Re: SP23-006 – Linscott-Kirk Short Plat – Technical Review 2
9803 48th Dr NE – APN(s): 00538500001200

MEMORANDUM

RE: Linscott-Kirk Short Plat, File# SP23-006
3 lot short plat
9803 48th DR NE & Parcel # 00538500001200

PRELIMINARY SHORT PLAT MAP  
 FOR  
**LINSCOTT-KIRK SP**  
 CITY FILE NO.

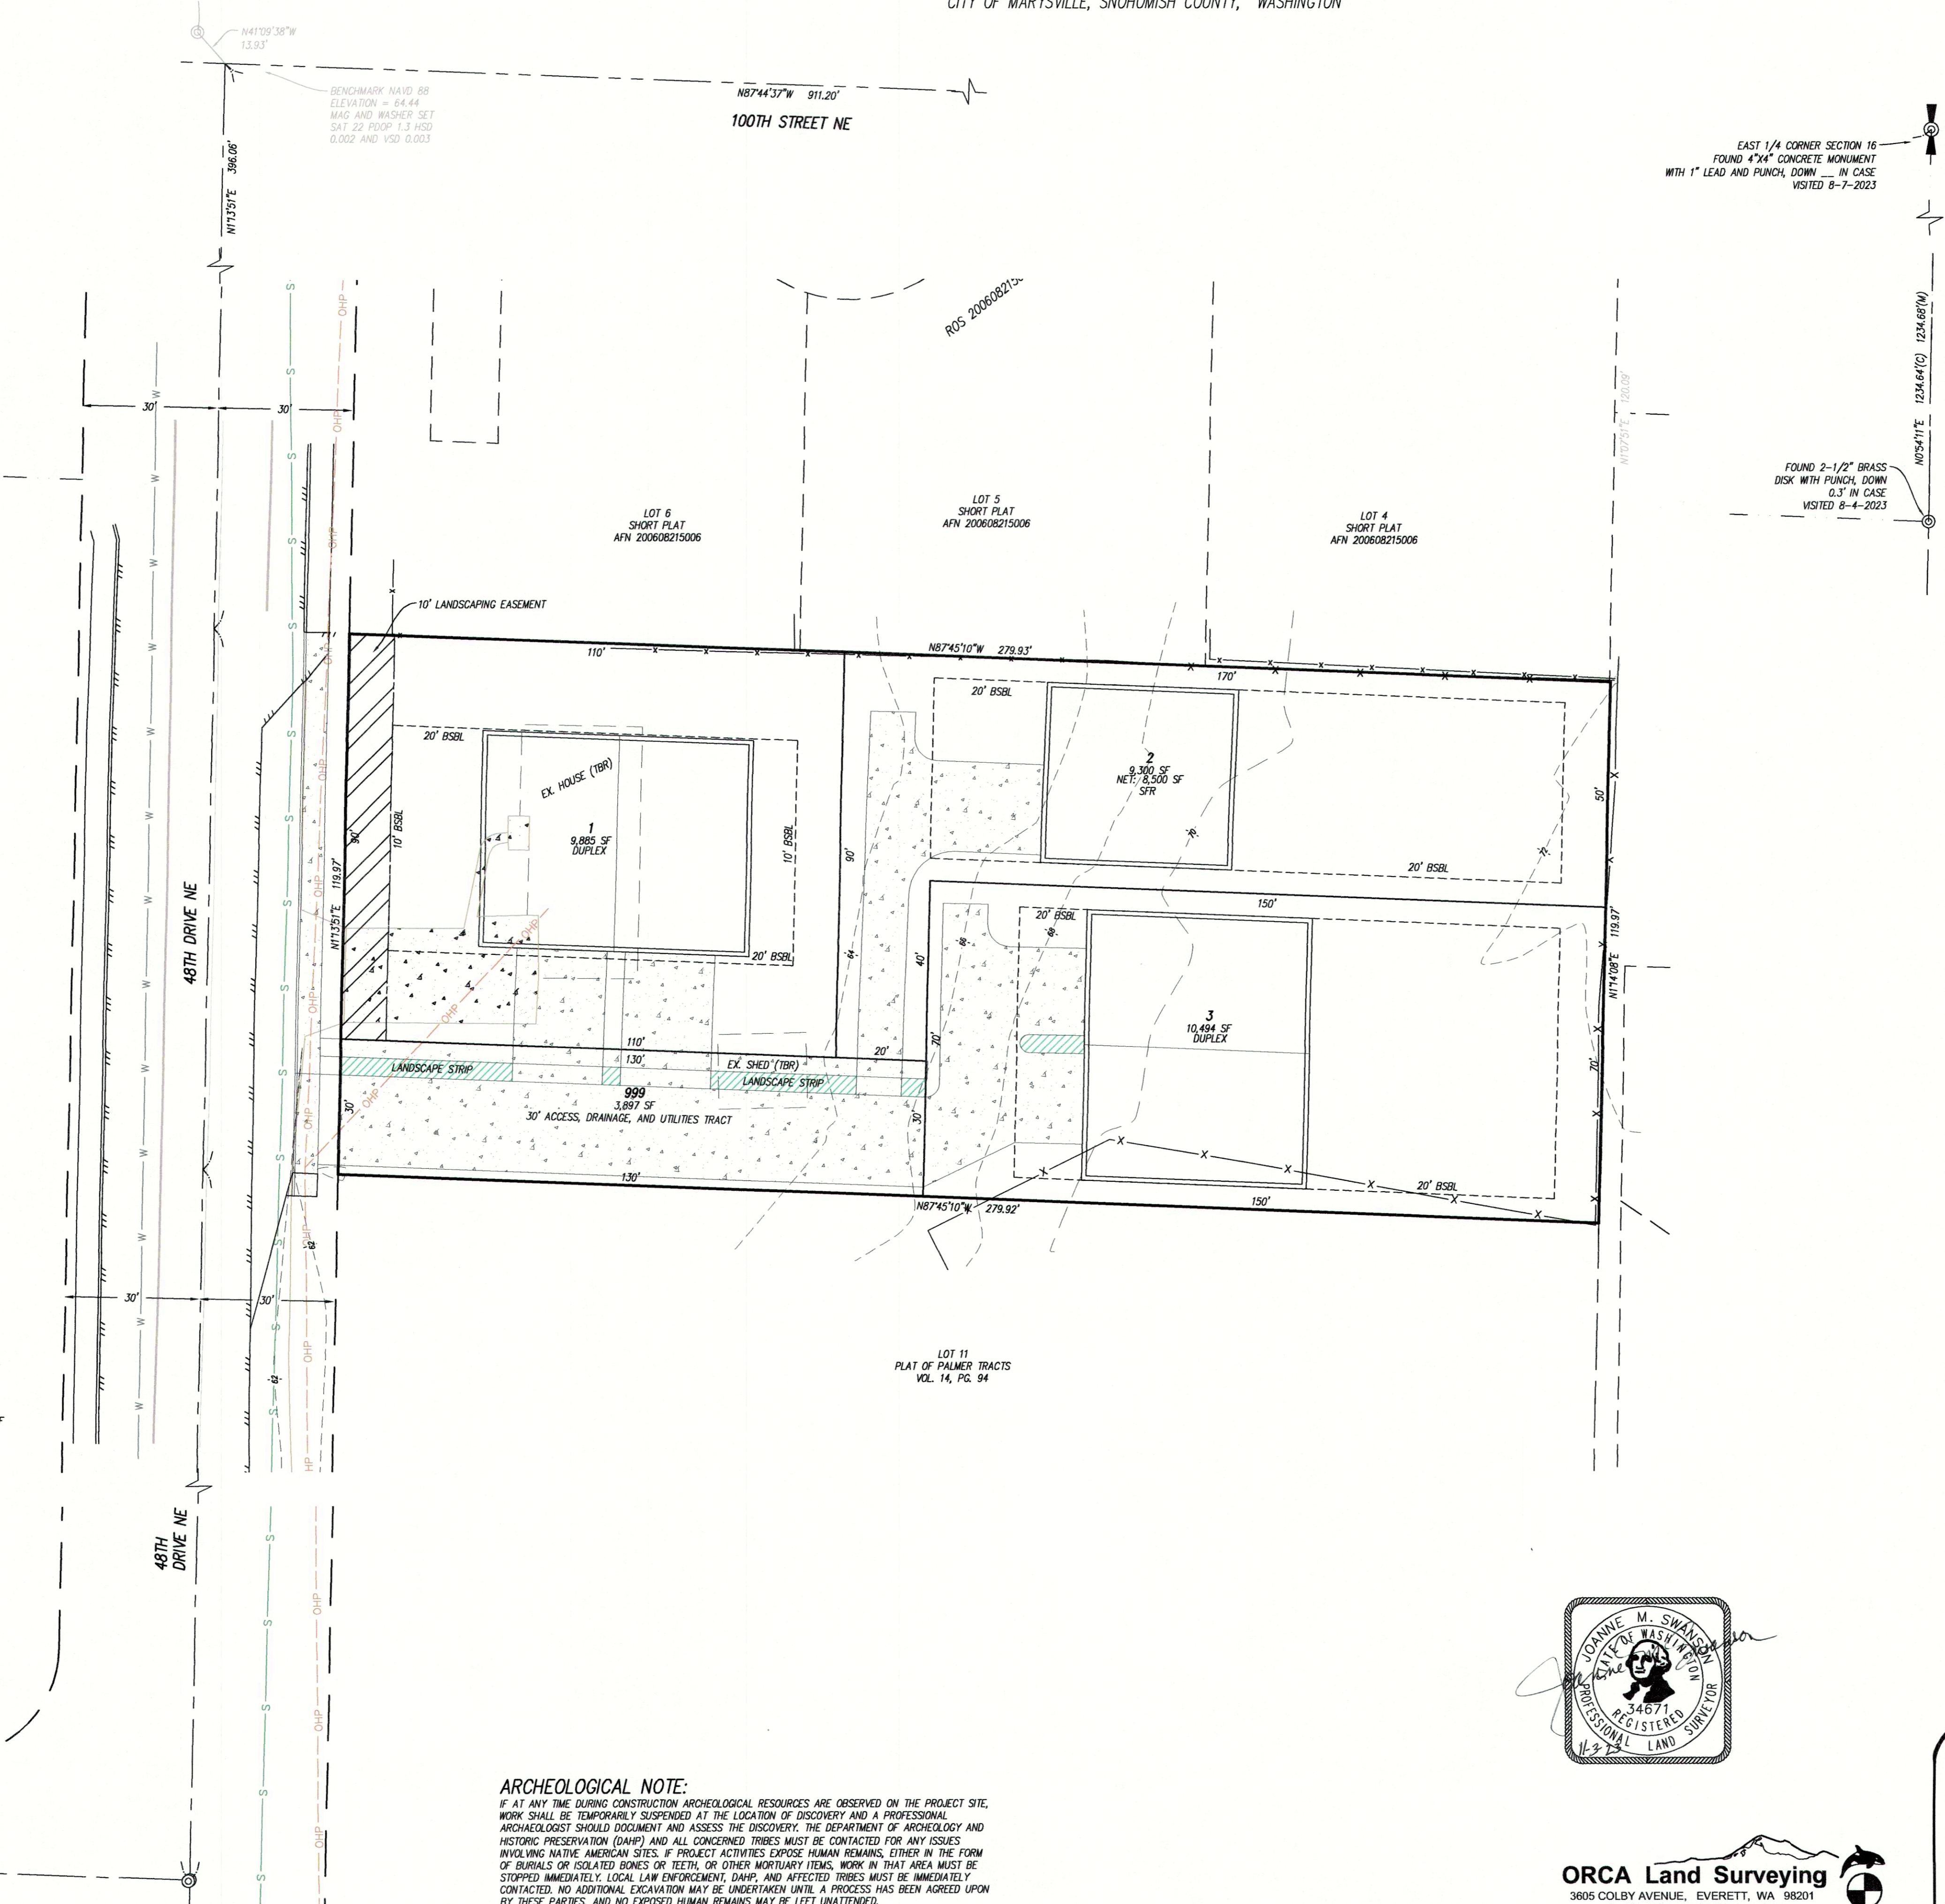
Please amend site plan to remove the proposed driveway for proposed Lot 1 to 48th Dr NE; only (1) driveway access is allowed.

- a. I'm not sure if lot 1 was submitted intending to have 2 driveway locations but we will not allow the driveway access off of 48th DR NE. The driveway must be off the new access tract.
- b. The minimum width of a residential driveway is 12-feet and the maximum is 26-feet. Curb cuts shall be limited to a 20 foot maximum.
- c. The new roads shall be constructed to SP 3-202-004.
